Our ref: HA/2017/119147/01-L01
Your ref: FP/21/17/PL
Date: 28 February 2017

1 NO. DWELLING WITH DETACHED GARAGE TO FRONT.

31 RIFE WAY, FELPHAM, PO22 7BN.

Environment Agency Position

Title			Survey and Proposals Plan		
Scale	1:500	At original	A4	© Robert Clark Associates Ltd	
Drawing Number	1724/S1.2		Revision	-

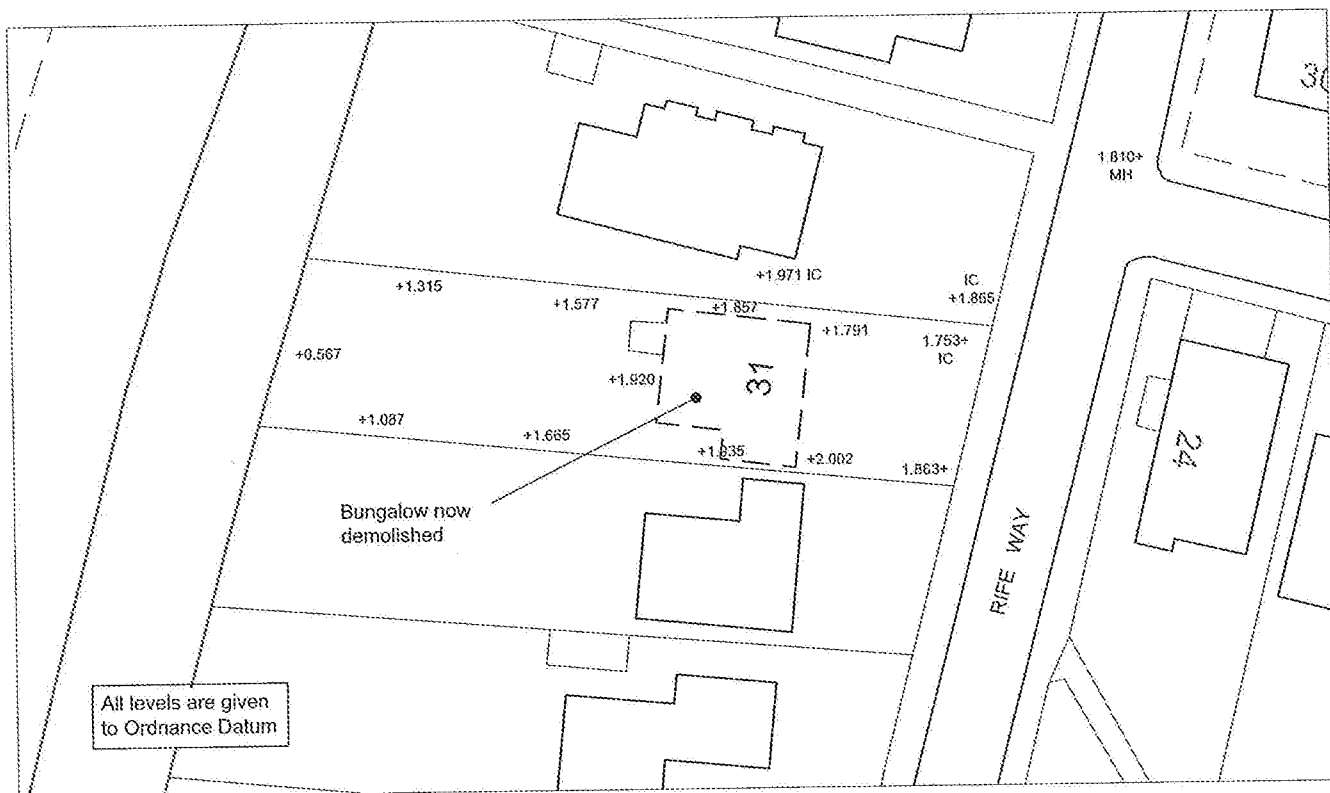
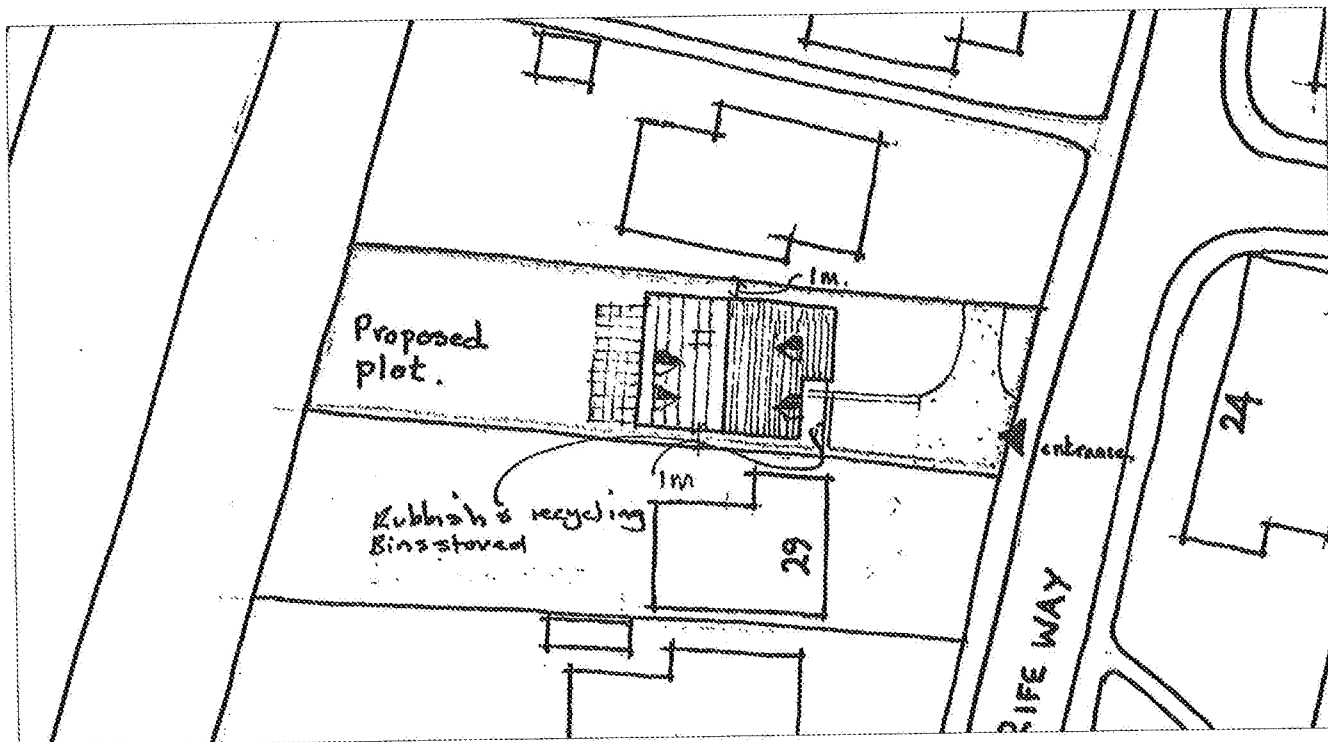
To overcome our objection the applicant/agent needs to provide details of existing ground levels so as comparisons can be made with the 1 in 200 tidal flood risk level of 5.0metres AOD so as potential flood depths and appropriate mitigation can be assessed.

It is acknowledged that historically a dwelling occupied the plot, and whilst it is unlikely that floor levels could match 5.0mAOD we would be looking for a finished floor levels to be set 300-600mm above existing land levels, so as the property and occupants are afforded suitable protection from flooding throughout its lifetime.
